Mountain View Electric Association, Inc. (MVEA) has these comments about the following:

**Project Name: Mountain to View Estates Minor Subdivision**

**Project Number: MS 183**

**Description:** Approval is being requested for Mountain to View Estates with three (3) residential lot on an approximately 40 acre parcel. This proposed subdivision is located west of North Ellicott Highway and south of Scott Road in Section 24, Township 12 South, Range 63 West.

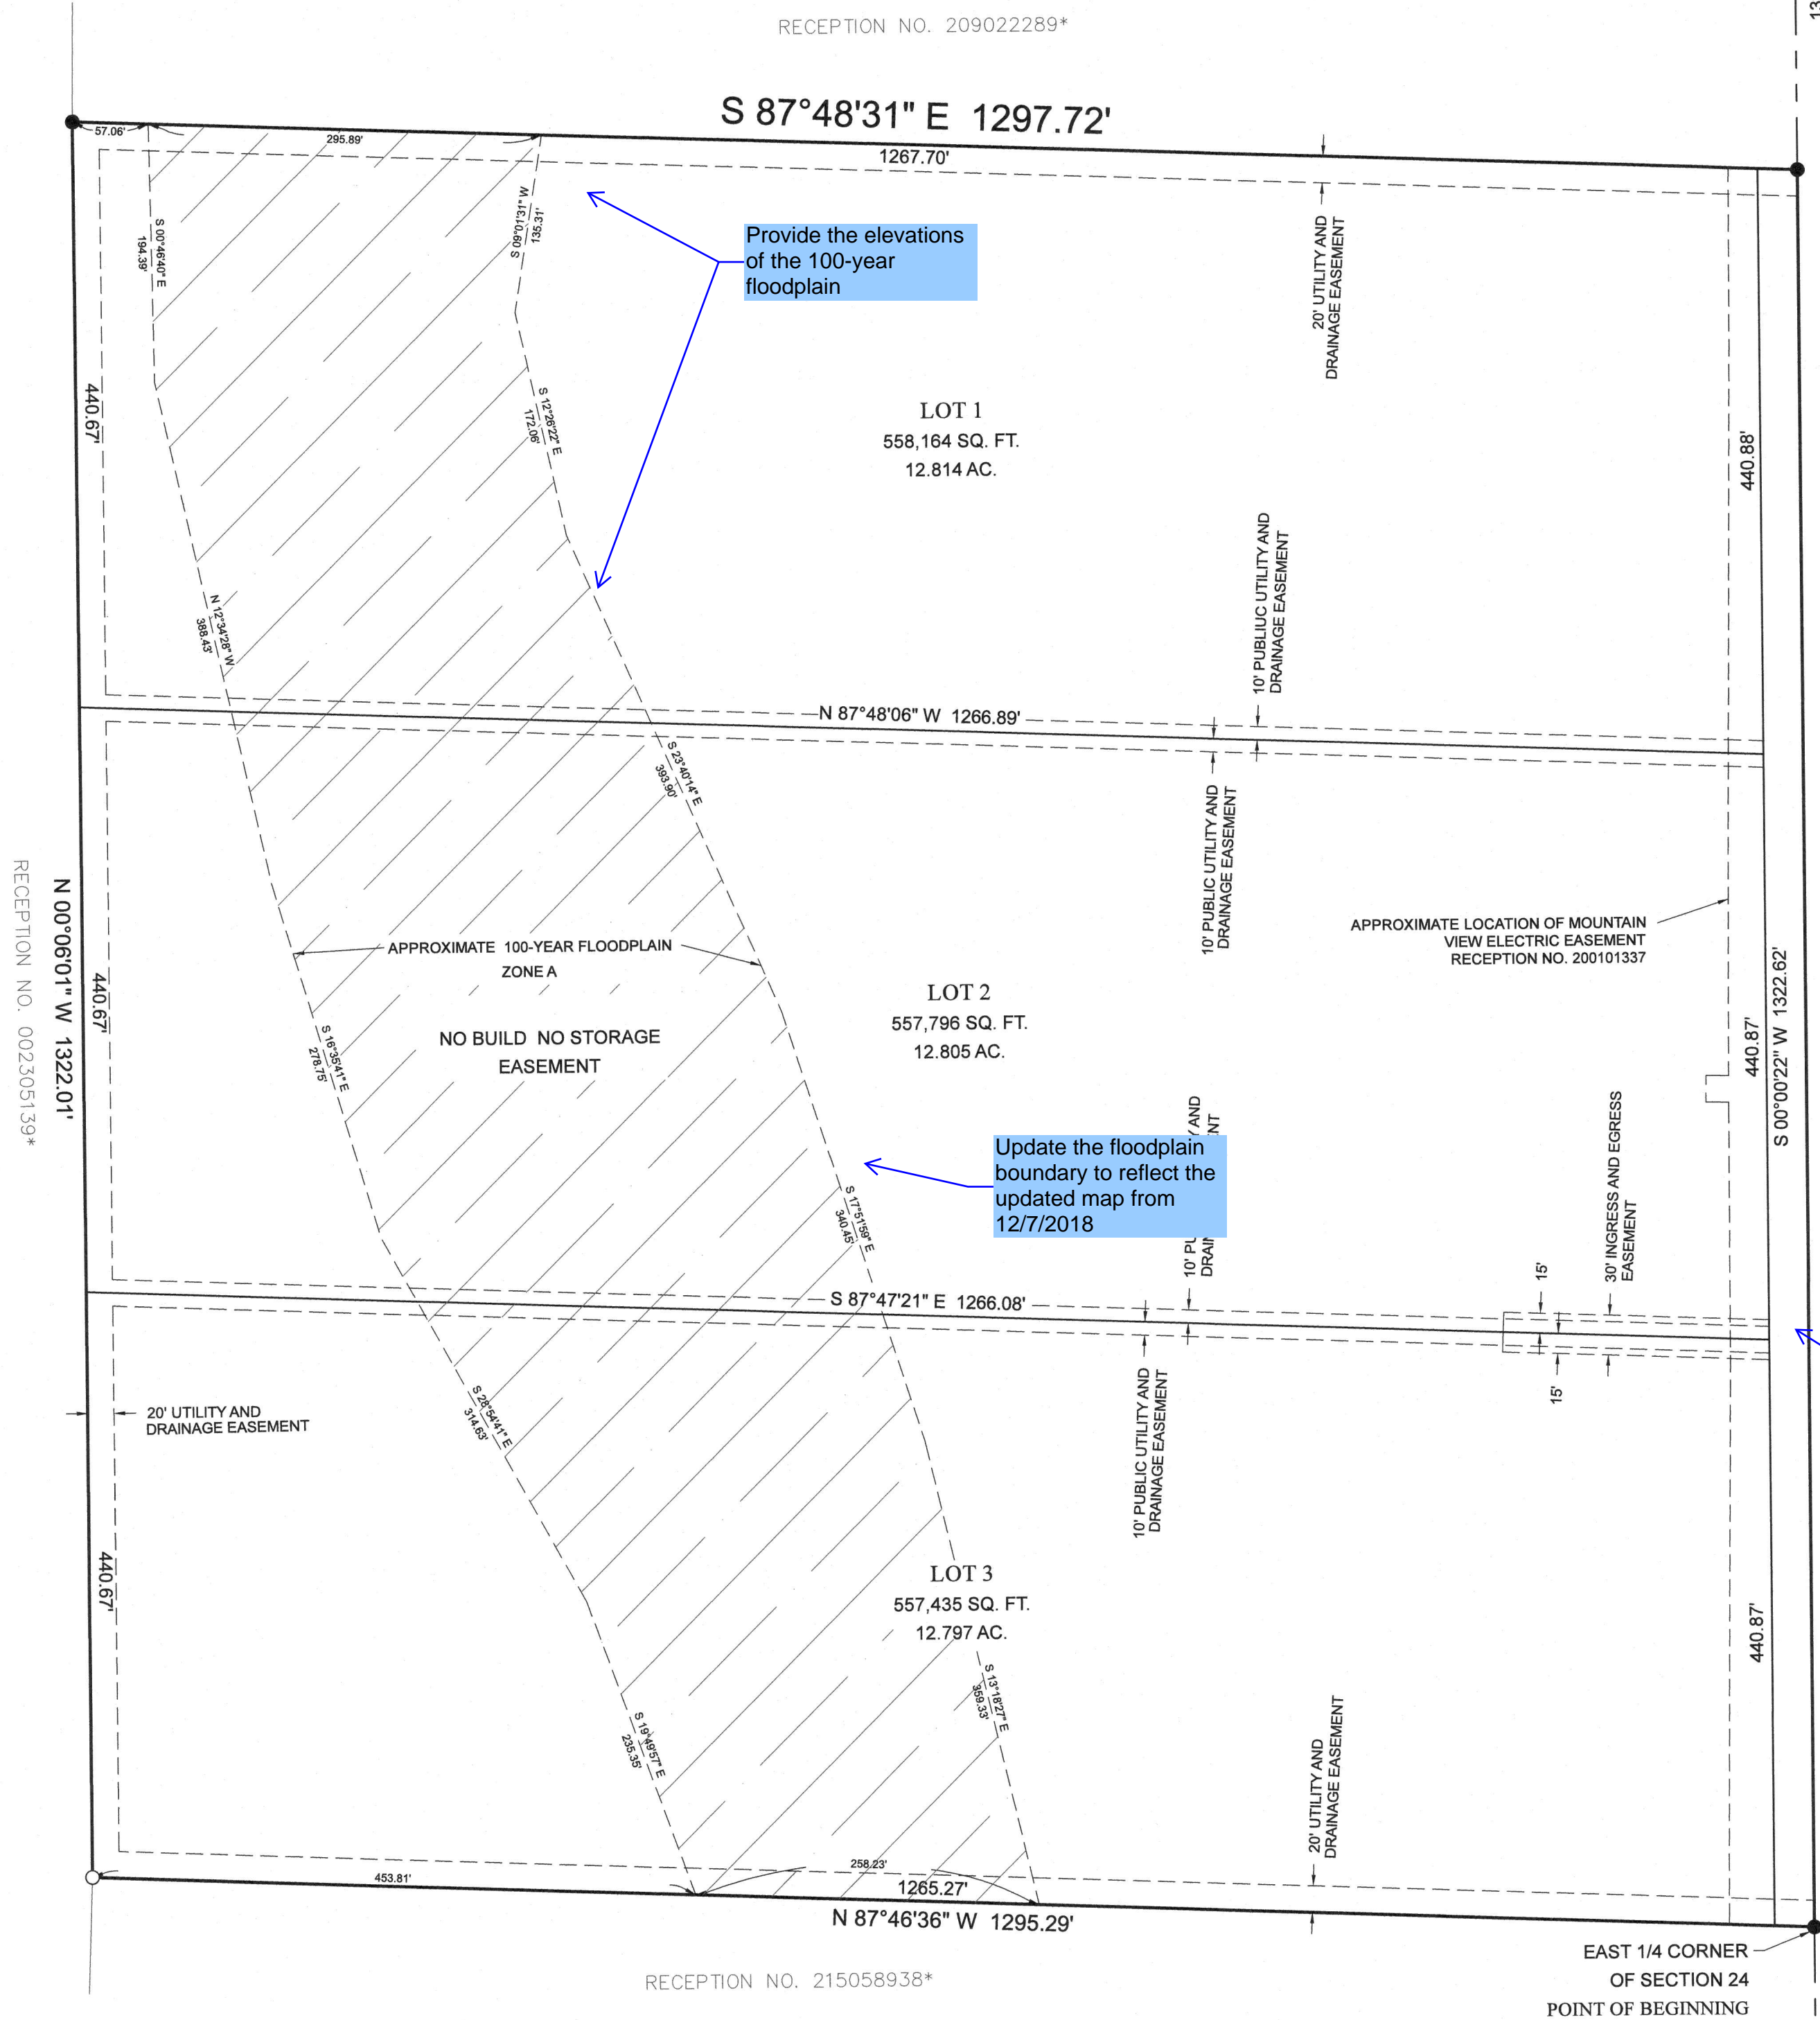
MVEA request utility easements of ten (10) foot side lot line along with twenty (20) foot front and rear lot line. MVEA also requests platting of existing MVEA facilities with easement on the plat.

MVEA has existing facilities near and within this parcel of land. If there is any removal or relocation of facilities it will be at the expense of the applicant.
